PROJECT NAME: **VANTAGE WIND POWER PROJECT COMMENTS RECEIVED**

Log: 111907-12-KT
Property: Invenergy Vantage Wind Power Project
Re: Archaeological Review and Comment

Subject: WSA-07-01, Vantage Wind Power Project (69 Wind Turbines, 103.5 MW)
Invenergy Wind North America LLC (4,750 Acres)
I-90, MP 125.00 – 131.30 Left (Ryegrass Rest Area 125.9 Left)
I-90, Exit 115 (Kittitas interchange – Badger Pocket Rd/Cleman Rd) vicinity
I-90, Exit 136 (Vantage interchange – Huntzinger Road) greater vicinity

Figure 6. Habitat and hedgehog cactus (*Pediocactus simpsonii*) populations for the proposed Vantage Wind Project development area.

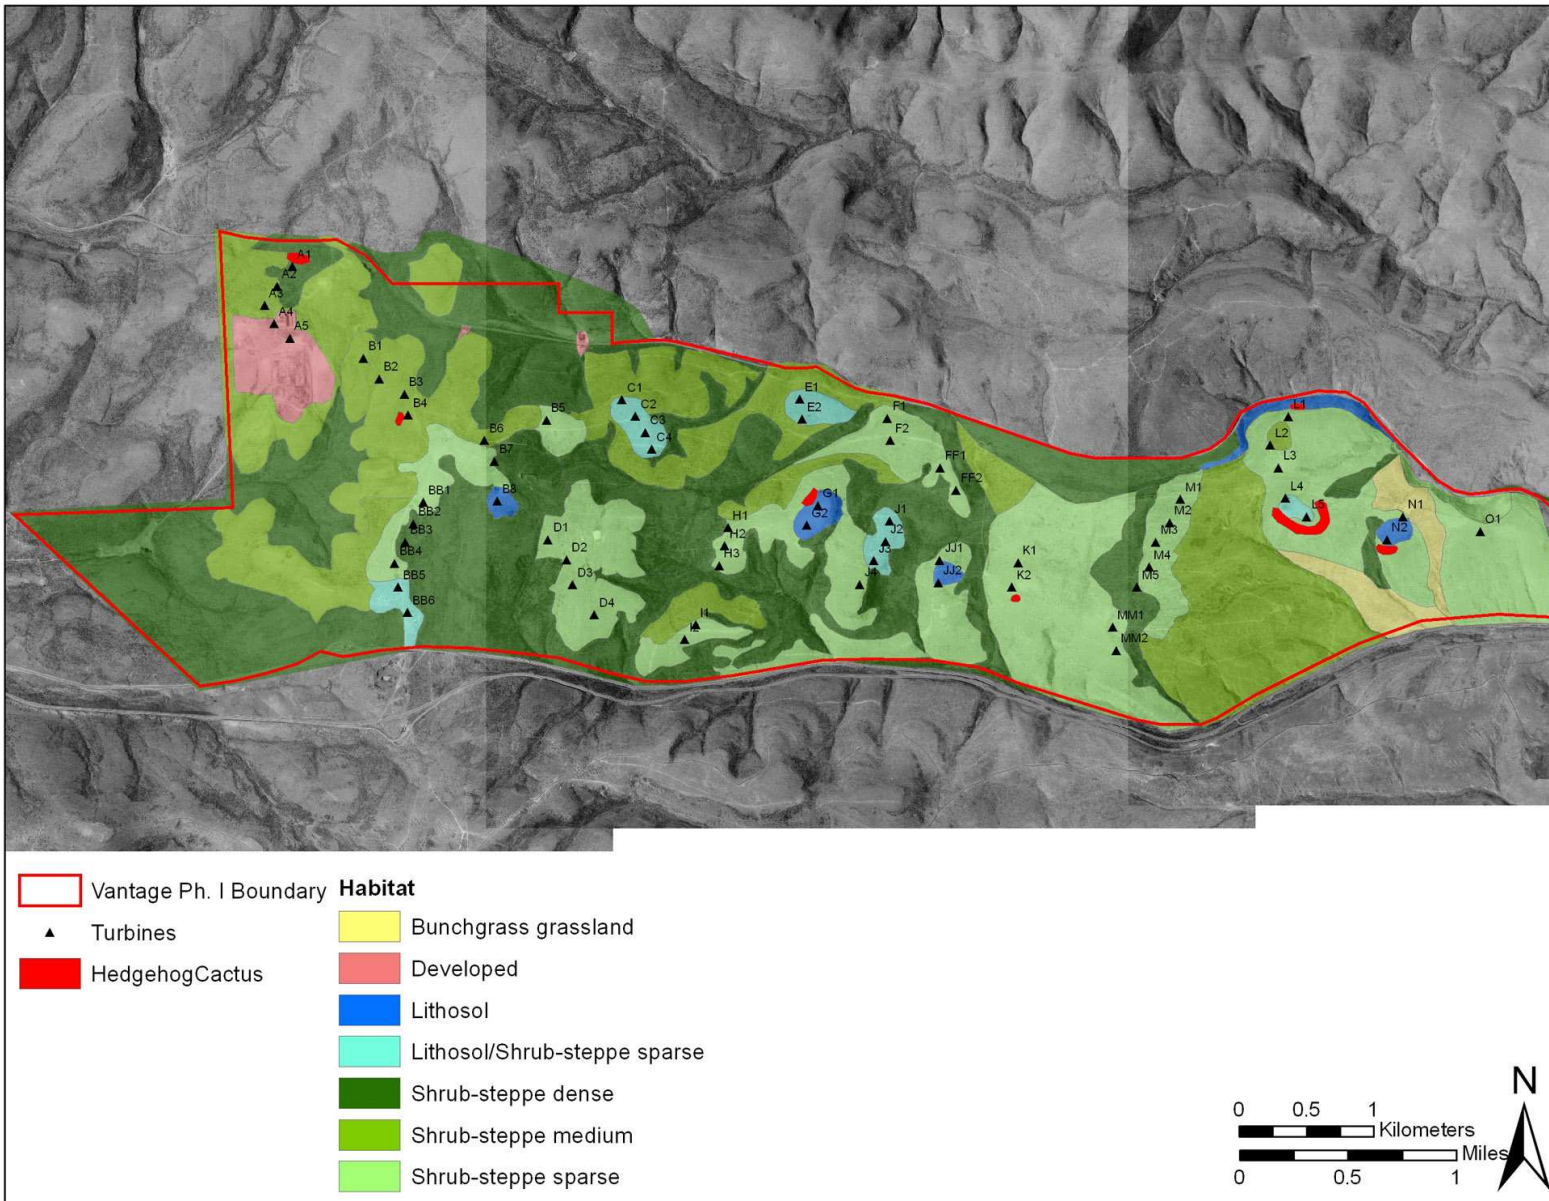
Another concern is the relocation of hedgehog cactus (*Pediocactus nigrispinus*), also known as snowball cactus, as mitigation. Relocation of individual hedgehog cactus plants has been successful in the Wild Horse Wind Power Project, but generally the transplanting of native plant species is not successful. The Natural Heritage Program does not support the relocation of rare plant species as an adequate mitigation measure.
